From: Anita Gardner
Sent: 18 January 2012 12:05
To: Planning.Responses
Subject: FW: EP/137/11/ - Replacement Gates - Willowhayne Estate
Attachments: GHD2003 The Ridings.pdf

From: Anita Gardner [mailto:Anita.Gardner@arun.gov.uk]
Sent: 17 January 2012 13:22
To: Rod Winrow
Subject: EP/137/11/ - Replacement Gates - Willowhayne Estate

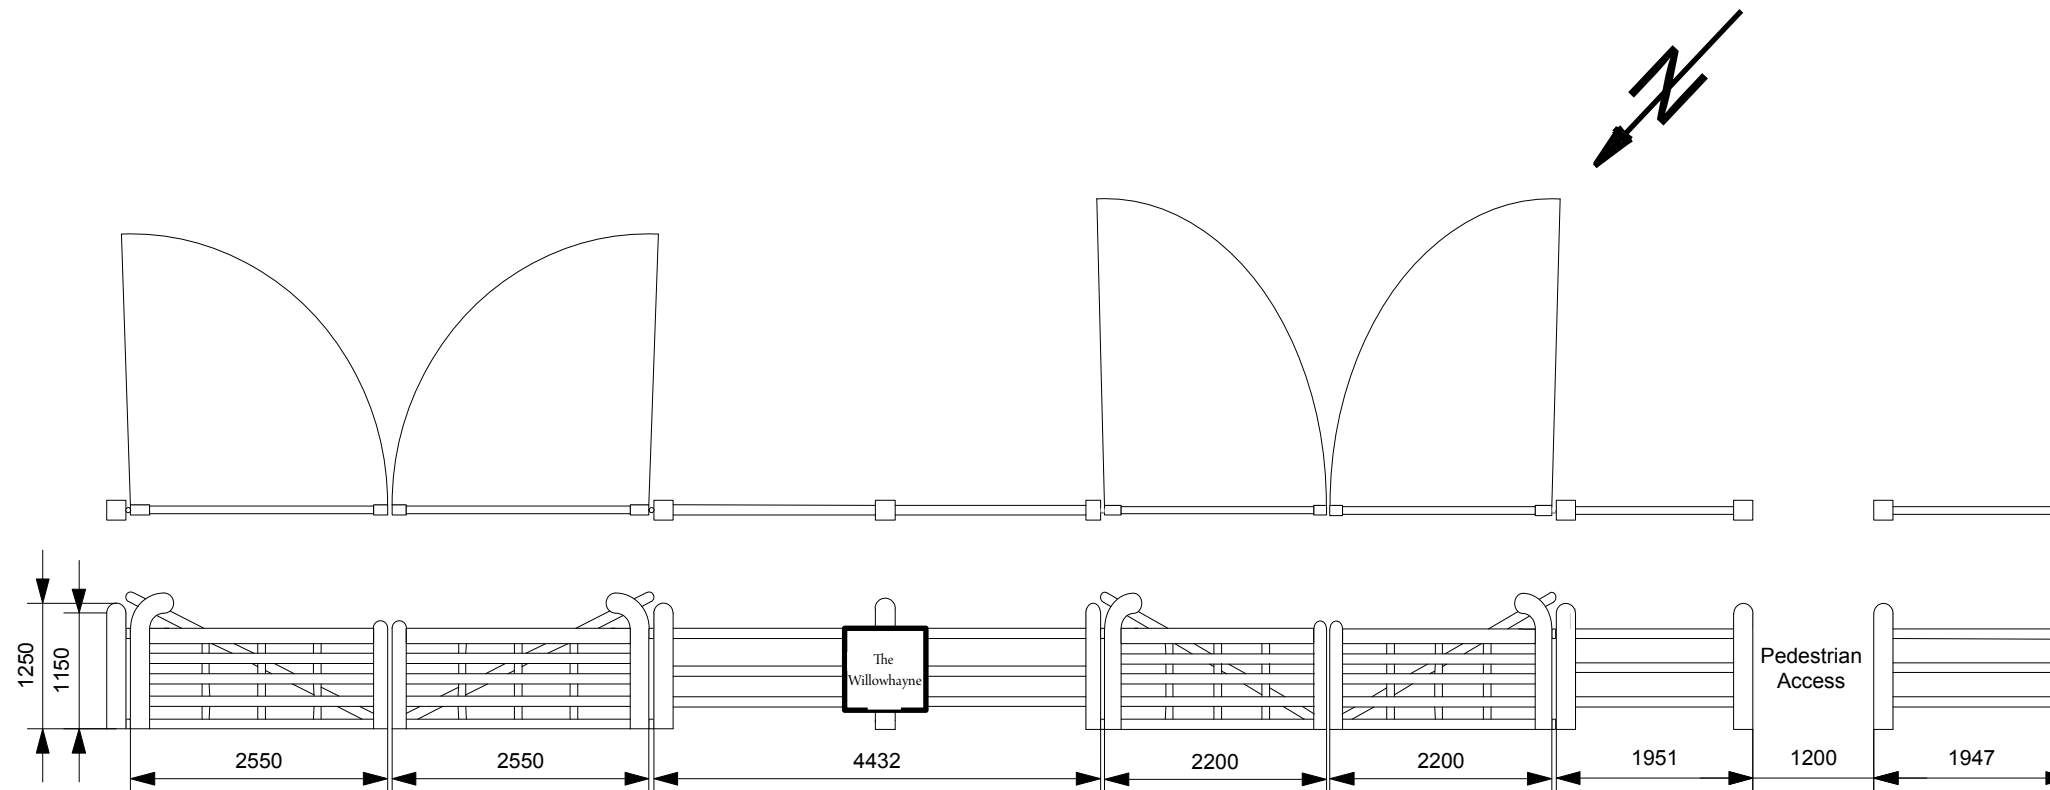
I have started looking through the above application and have noticed that there is no elevation plan of the proposed gates for 'The Ridings'. In addition all of the submitted plans have the note 'do not scale from drawing' which is not acceptable, since we do need to scale from the plans. Please can you either amend this note to relate to 'except for planning purposes' or confirm in writing that I can add this note to the submitted plans.

1. My apologies for the missing plan. Please see attached our elevation plan for the Ridings.
2. I can confirm that we are happy that you add a note to the submitted plans "except for planning purposes"
3. The new pedestrian access to the estate will be a minimum of 1.2m wide, which will offer access for a range of mobility of vehicles, up to class three vehicles that have a maximum width of 0.85m.
 - Tamarisk present pedestrian access 90cm
 - Angmering lane 65cm and 97cm
 - The Ridings 100cm
4. The 5 bar gate was chosen as it was felt that this design would be more in keeping with the surrounding area, and add additional strength to the structure. However The Association would be happy to consider a three bar option.
